Babergh District Council and Mid Suffolk District Council (20041302)

Deadline 6 submission for Bramford to Twinstead (EN020002)

TITLE
 2.11.5 DESIGN AND LAYOUT PLANS: DEDHAM VALE EAST CABLE SEALING END COMPOUND

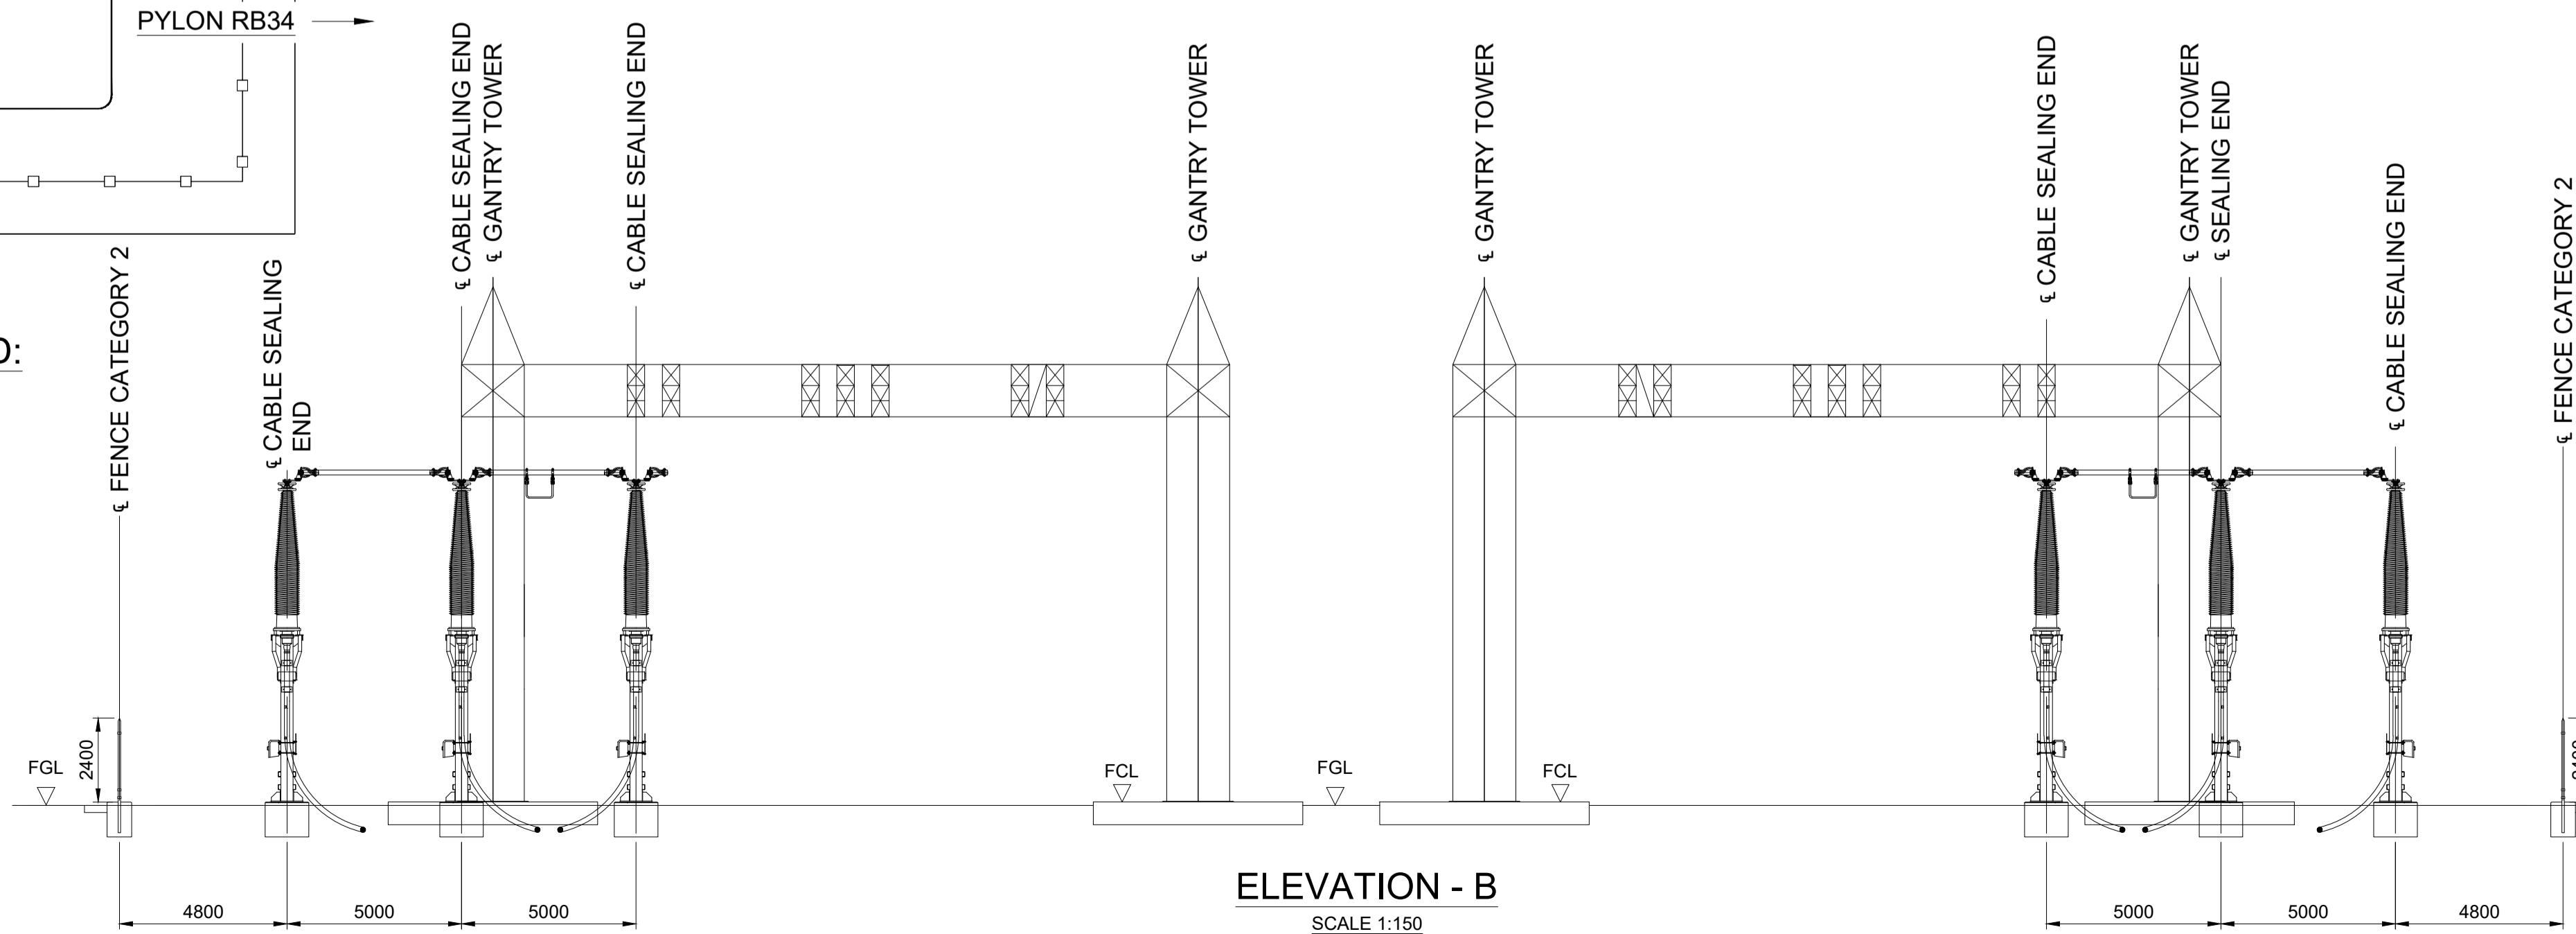
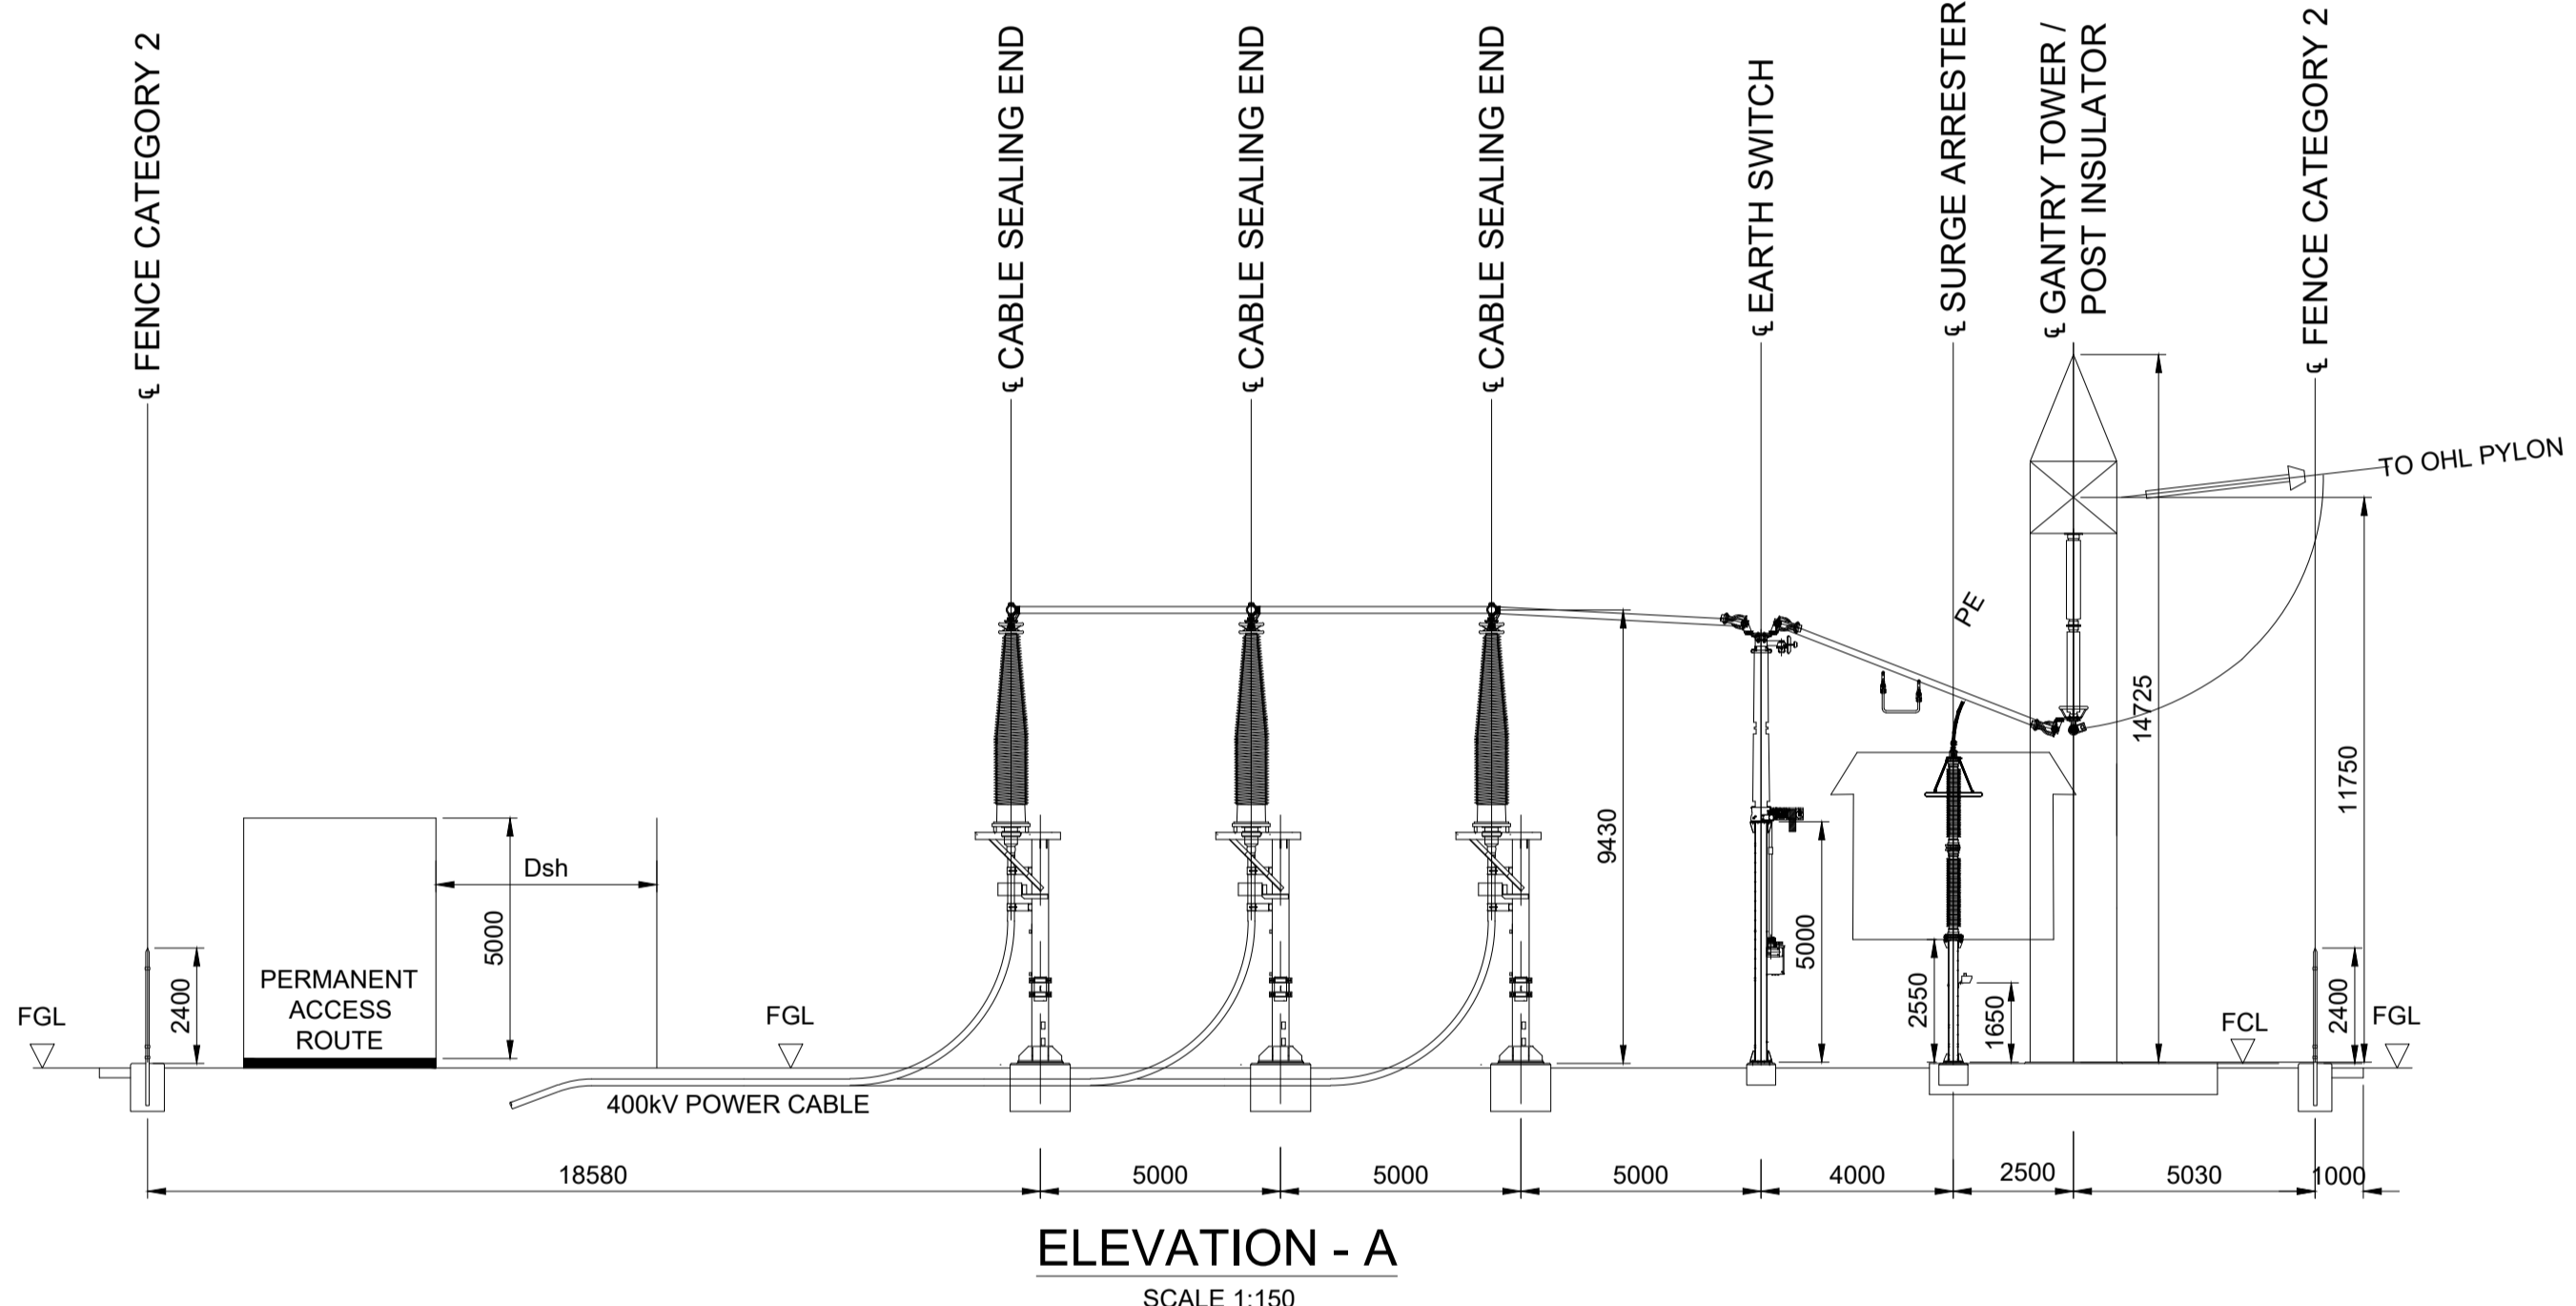
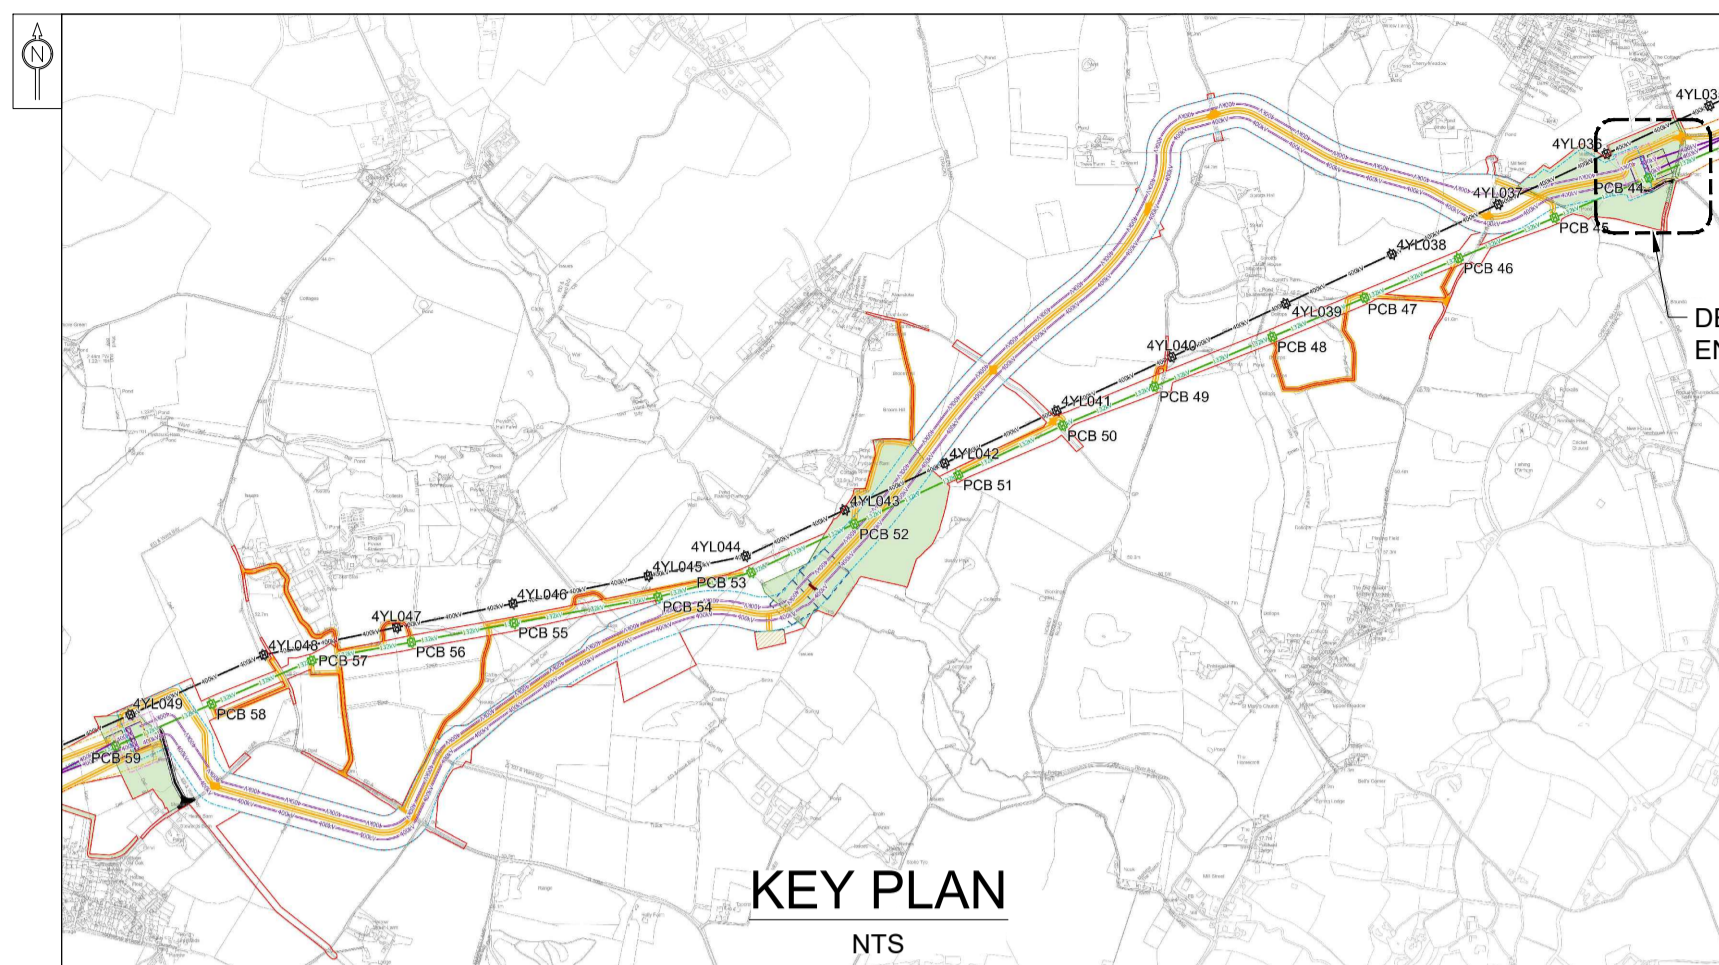
Re 3.5 Visual mitigation planting at the CSE compounds - Dedham Vale East: The applicant responds, *'The hedgerow is reinforced by blocks of woodland and scrub planting which have been positioned to screen views for people travelling south Millwood Road'*. The Councils still have concerns that views into the site and of the facility will be available via the entranceway without additional planting close to the facility, and that mitigation of the visual effects is not demonstrated.
